Wesley College

Submission in Response to Application for State Significant Development SSD 5087-2011 University of Sydney- Science Research & Education Facility (Australian Institute of Nanoscience)

**Submission in response to Application for State Significant Development
SSD 5087-2011 University of Sydney - Science Research & Education Facility (Australian
Institute of Nanoscience)**

Figure 5a Eastern Ave to Wesley College pathway

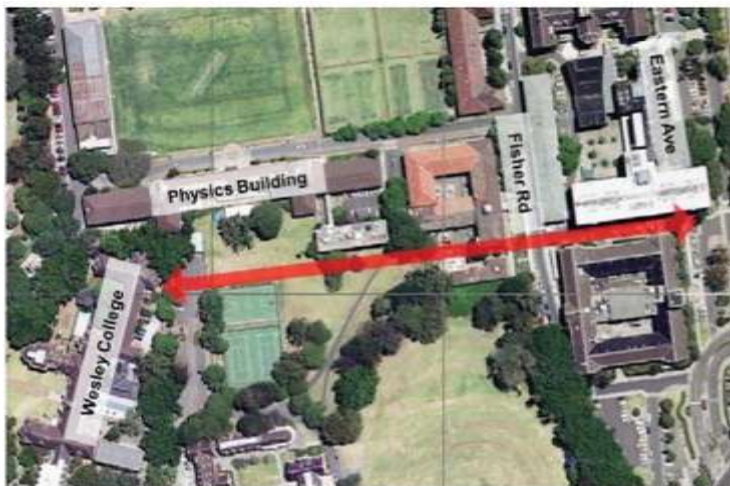
The Eastern Ave to Wesley College pathway access (Fig 5a- body of the EIS report Page 15) is of concern. Specifically, it appears that pedestrians will utilise the pathway between Wesley College's Purser Wing and Physics building.

The development is seeking 24/7 operations (P30) and there are a large number of students envisaged with access to the Southern Entry from Fisher Road. There is no consideration of potential noise or privacy impacts related to students using the passageway past the Purser Wing rooms, where students study, sleep, and generally require privacy.

The body of the EIS references an Arup Transport Impact Report when assessing pedestrian routes. However, the Arup Transport Impact Report assesses a completely different pedestrian route (Page 4/5) to the one discussed in the body of the EIS (Page 15 Fig 5a). It appears that the EIS has taken a different approach to what Arup's specialist consultants advised and this should be substantiated. Access to the AIN building should not be designed to include/promote access through the Wesley Pathway, and potential impacts to Wesley should be assessed, and mitigation measures must be to be put in place to actively discourage it.

drawing
Site Plan - Shadow Analysis - Summer Solstice

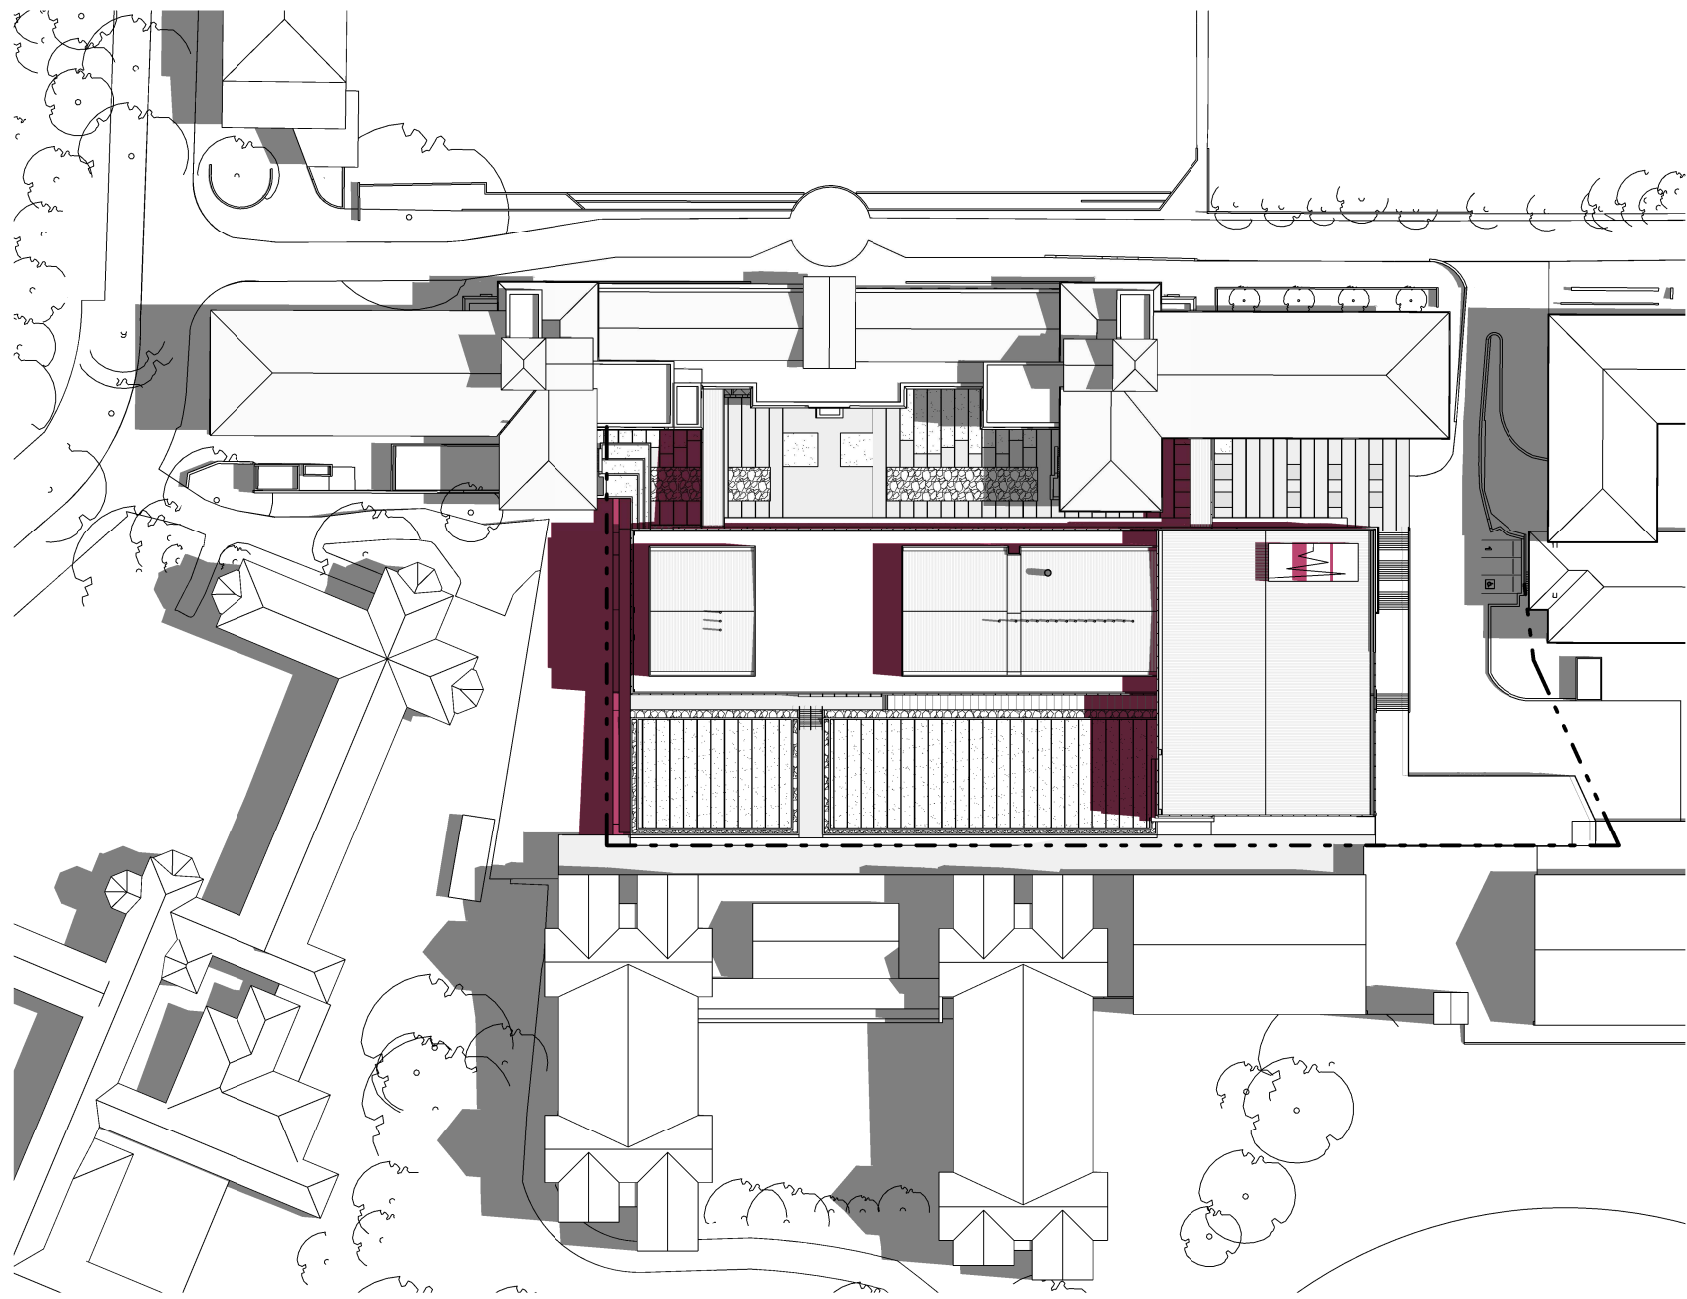
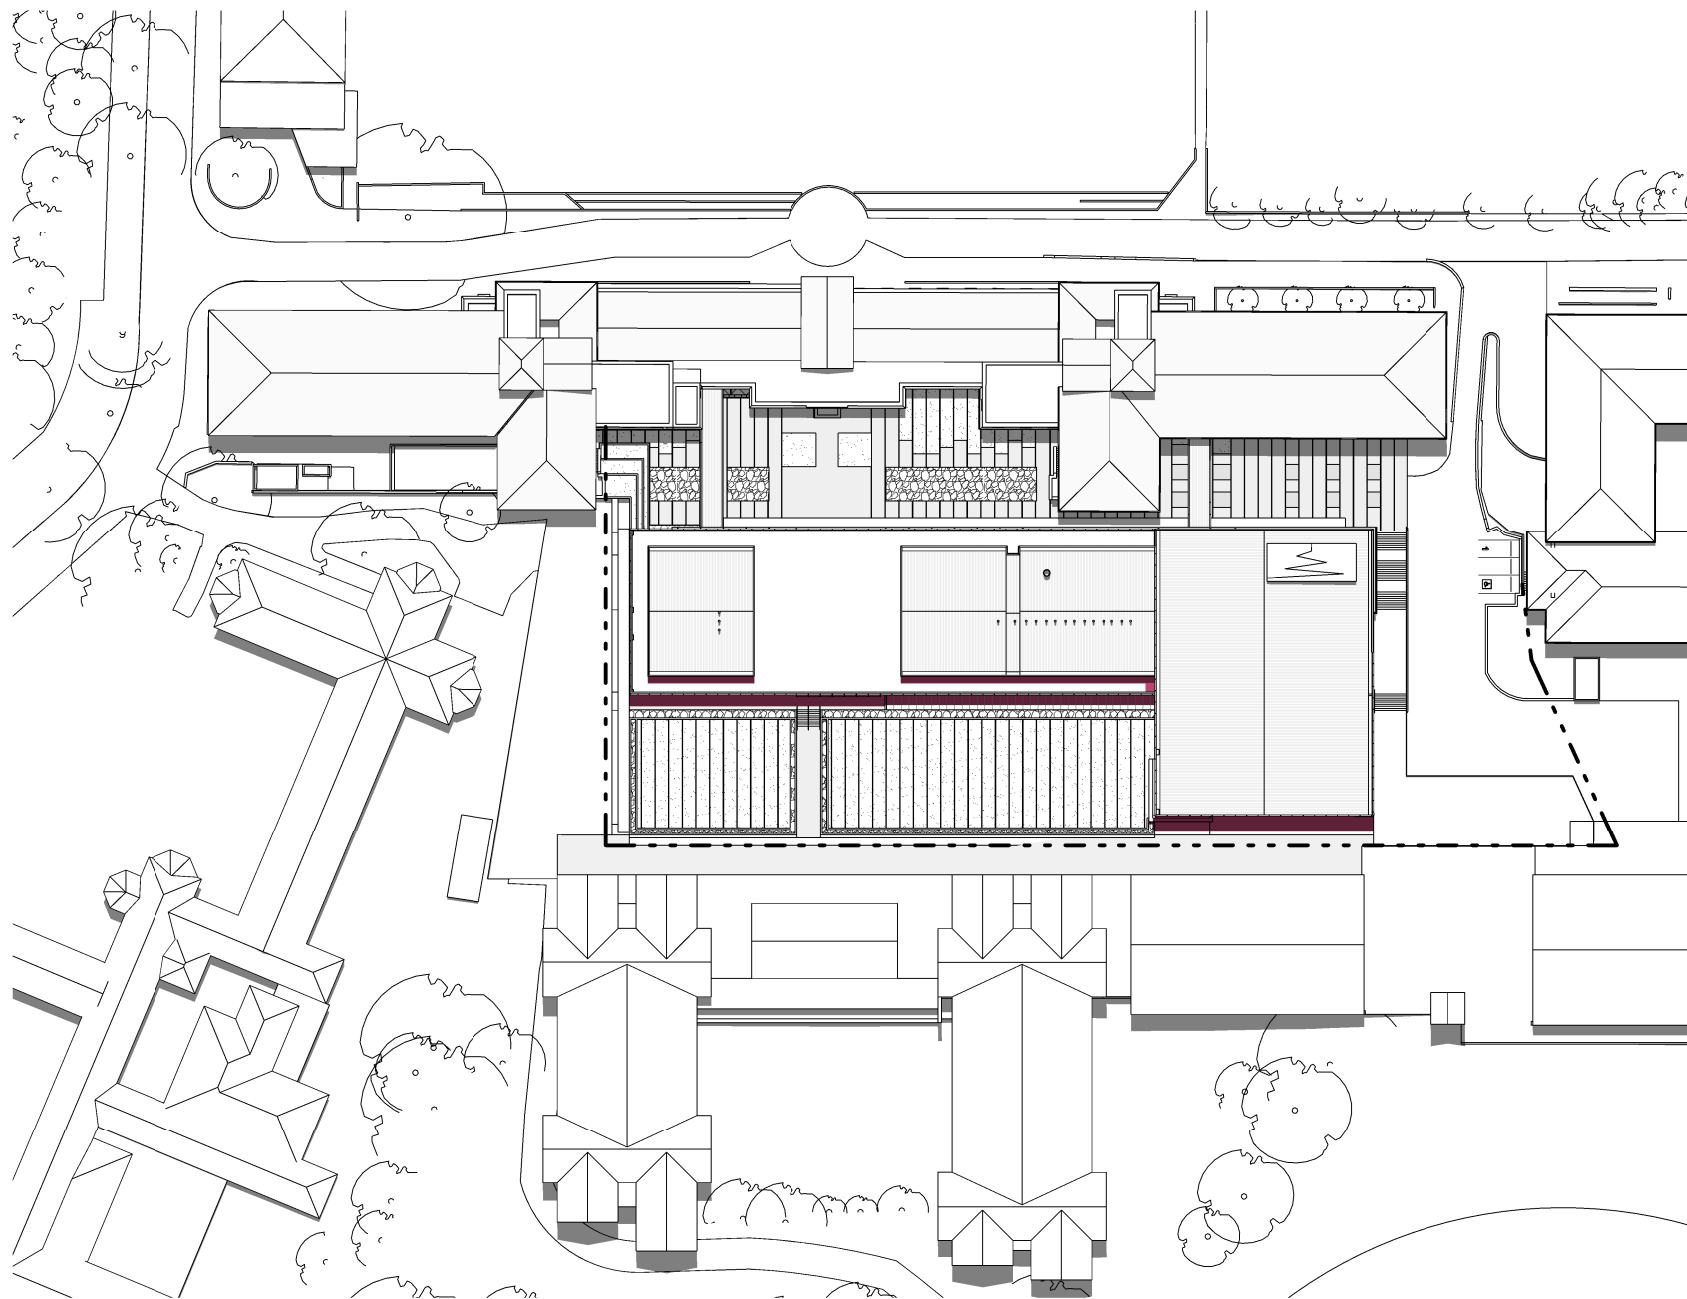
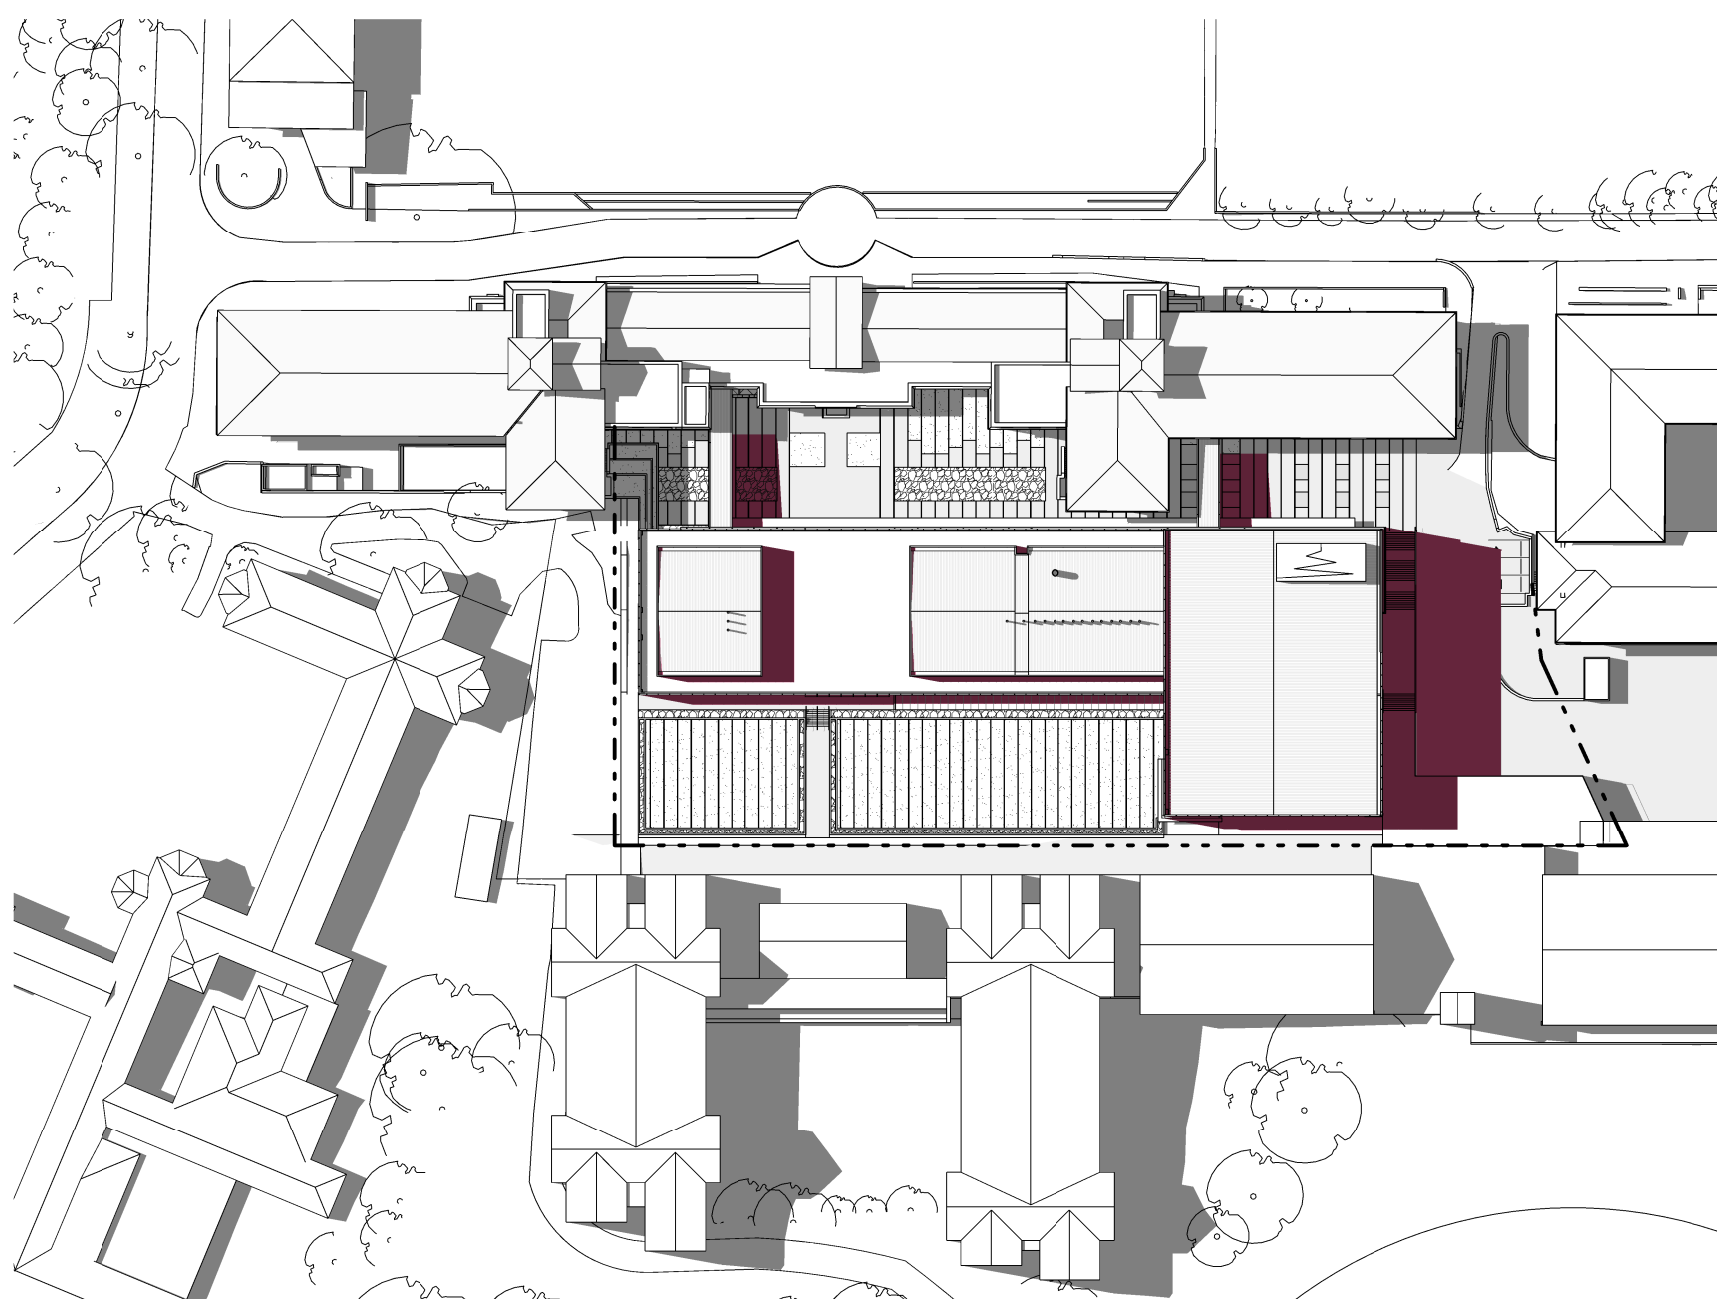
Purser Wing is a strictly residential building with each student bedroom having one window only with access to daylight. All bedrooms facing east are potentially impacted from the presence of the Nano building in terms of over shadowing, and the potential elimination of direct sunlight that can penetrate into the bedrooms. The shadow diagrams supplied, dwg A-1051, are small in scale and we cannot be certain that morning winter sun is not lost from some bedrooms.

The accuracy of the shadow diagrams is in question in relation to actual floor and ground levels as, for example, on dwg A-1051, 3pm Dec 21 diagram shows a lengthy shadow cast by the substation building behind the Purser Wing, when in fact at the east edge of the substation roof is virtually at ground level and no shadow will be cast.

The applicant should be asked to check the shadow studies and provide larger detail drawings of winter shadows at 9,10 and 11am June 21st. The correct way of illustrating non-impact on Purser would be elevational studies of the shadows on the Purser east wall.
